From: Tom Winter [REDACTED]
Sent: 07 October 2020 12:14
To: Nicola Moore
Cc: Carl Pringle; Carl Pringle
Subject: 58 Felpham Way - PLANNING APPLICATION AMENDMENTS - FP/190/20/PDH
Attachments: 58 Felpham Way_PLANNING_EXISTING AND PROPOSED DRAWINGS.RevB.pdf

RE: 58 Felpham Way - PLANNING APPLICATION AMENDMENTS - FP/190/20/PDH

BLOCK PLAN (dashed line indicates proposed rear single-storey extension)  
Scale 1:500

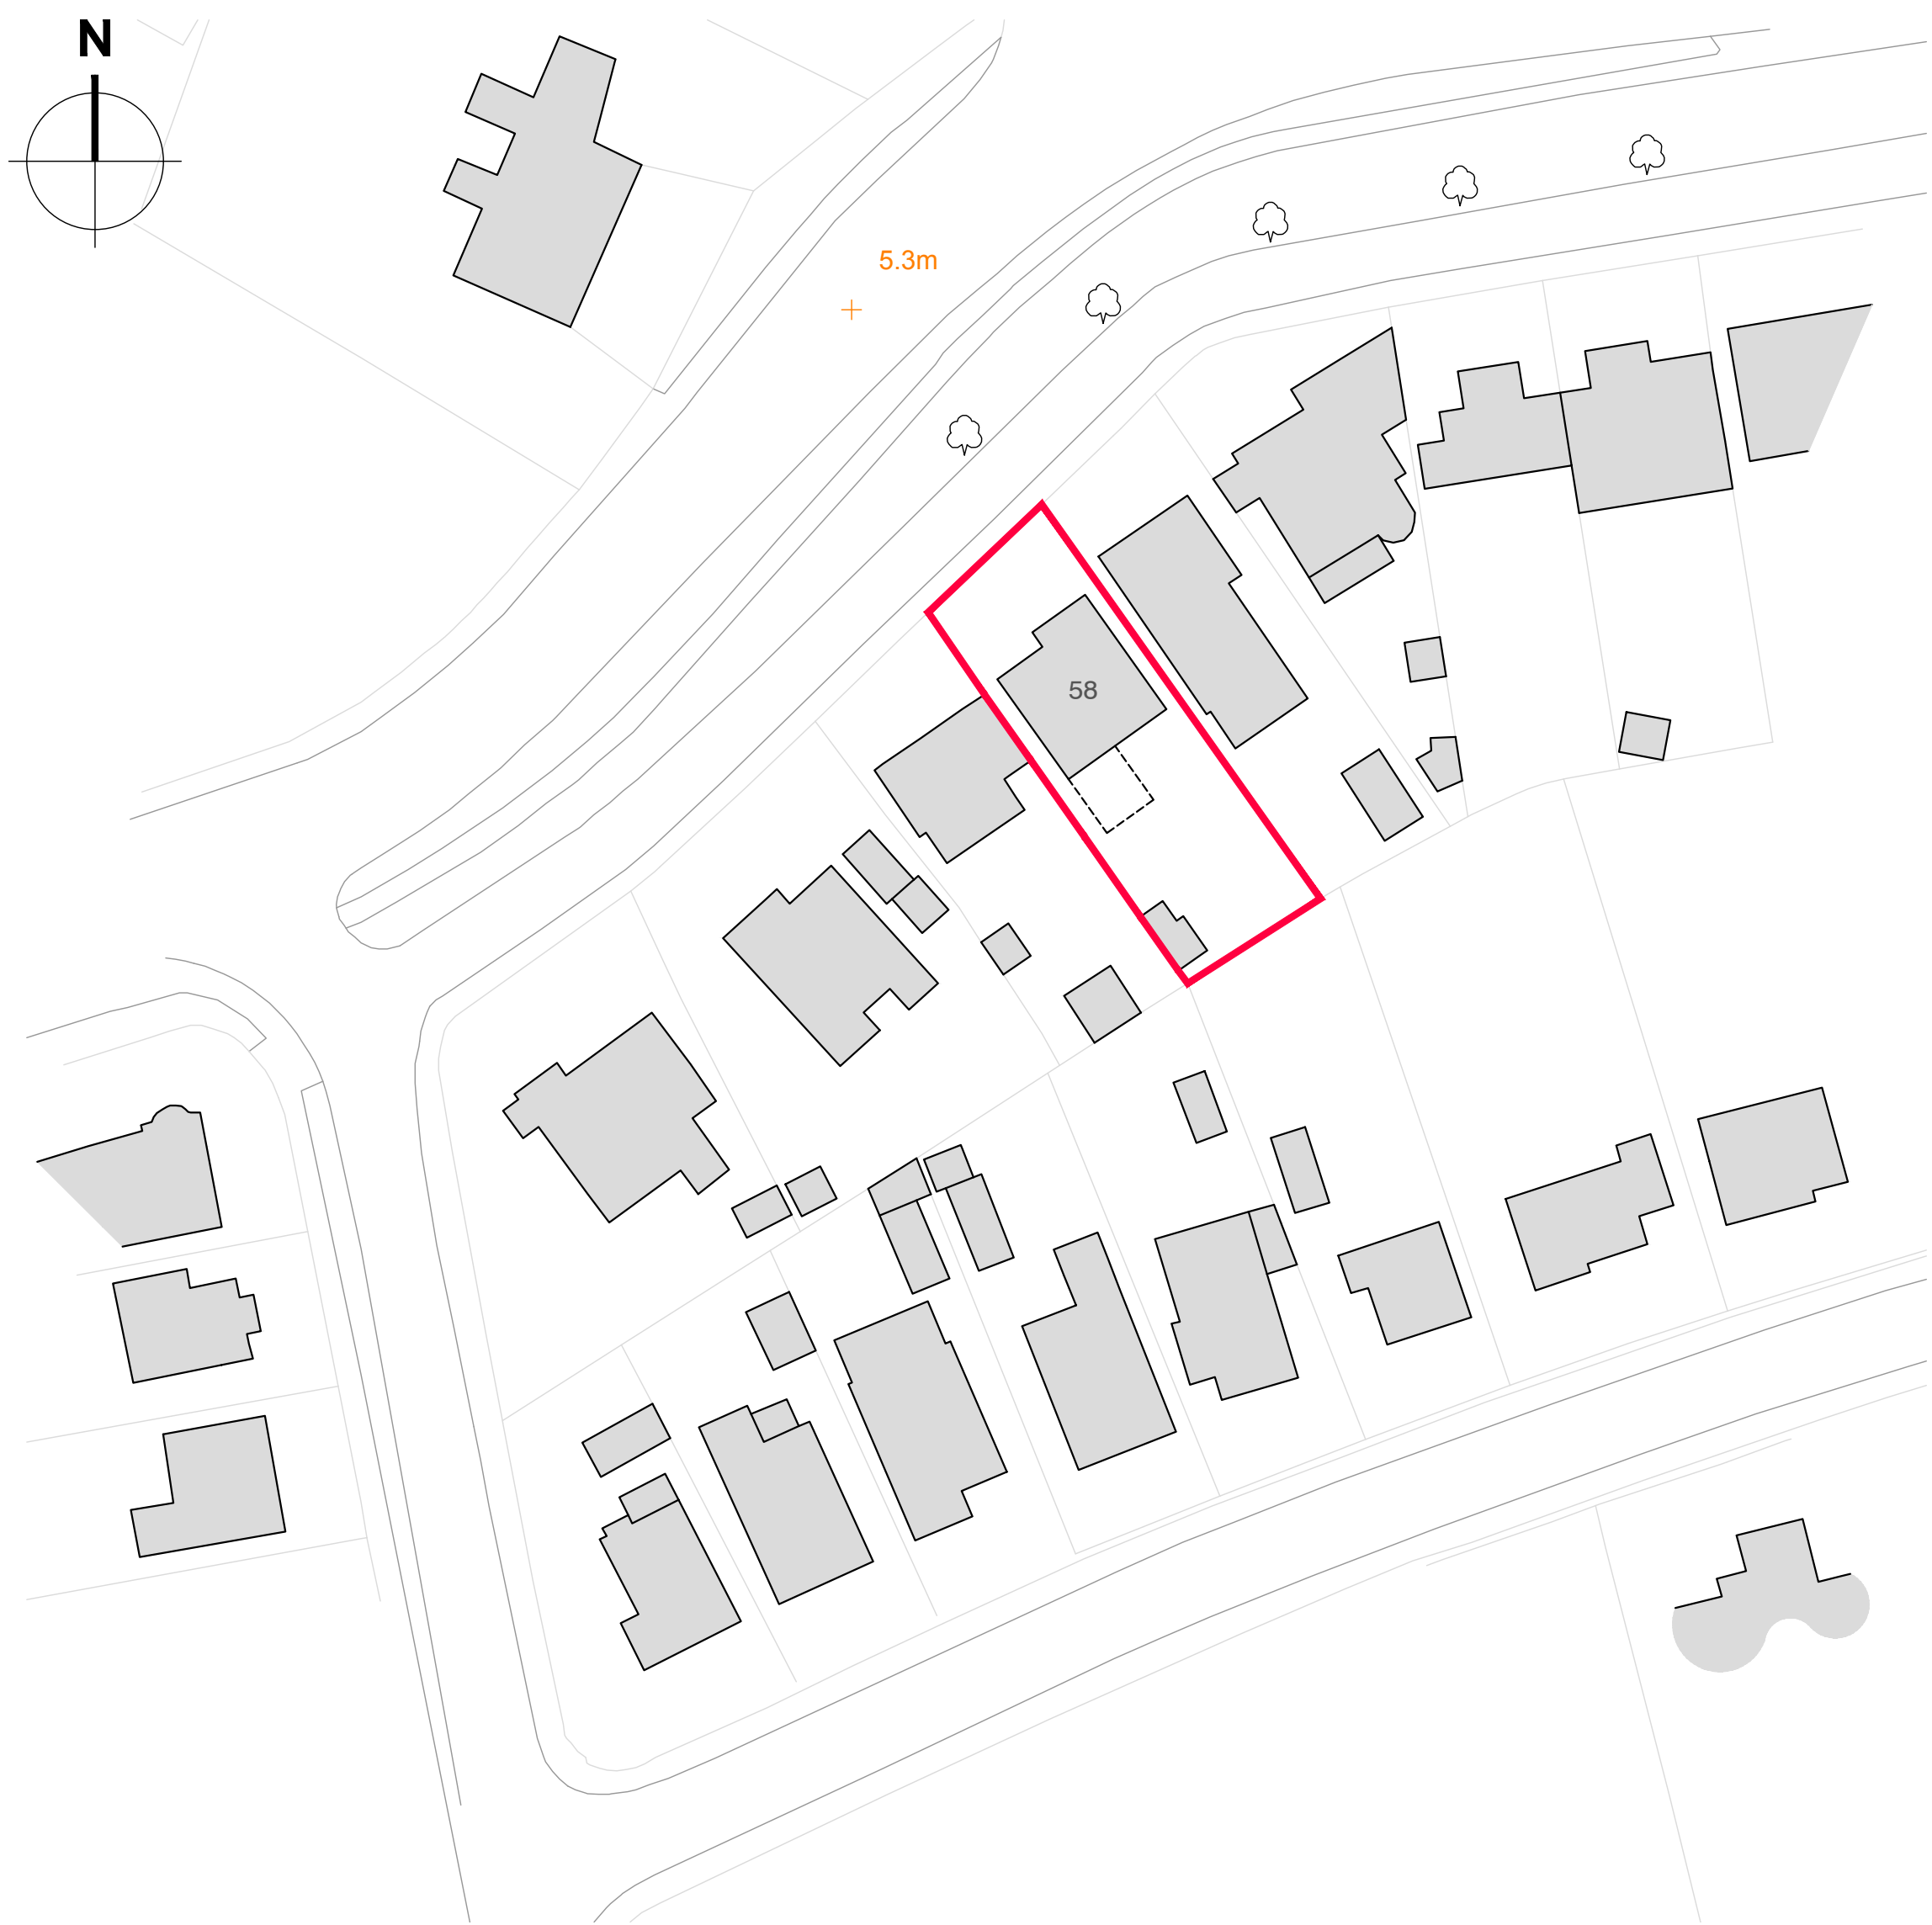
Following your email please find attached the amended drawings with the Block Plan 1:500 now indicating the proposed development.
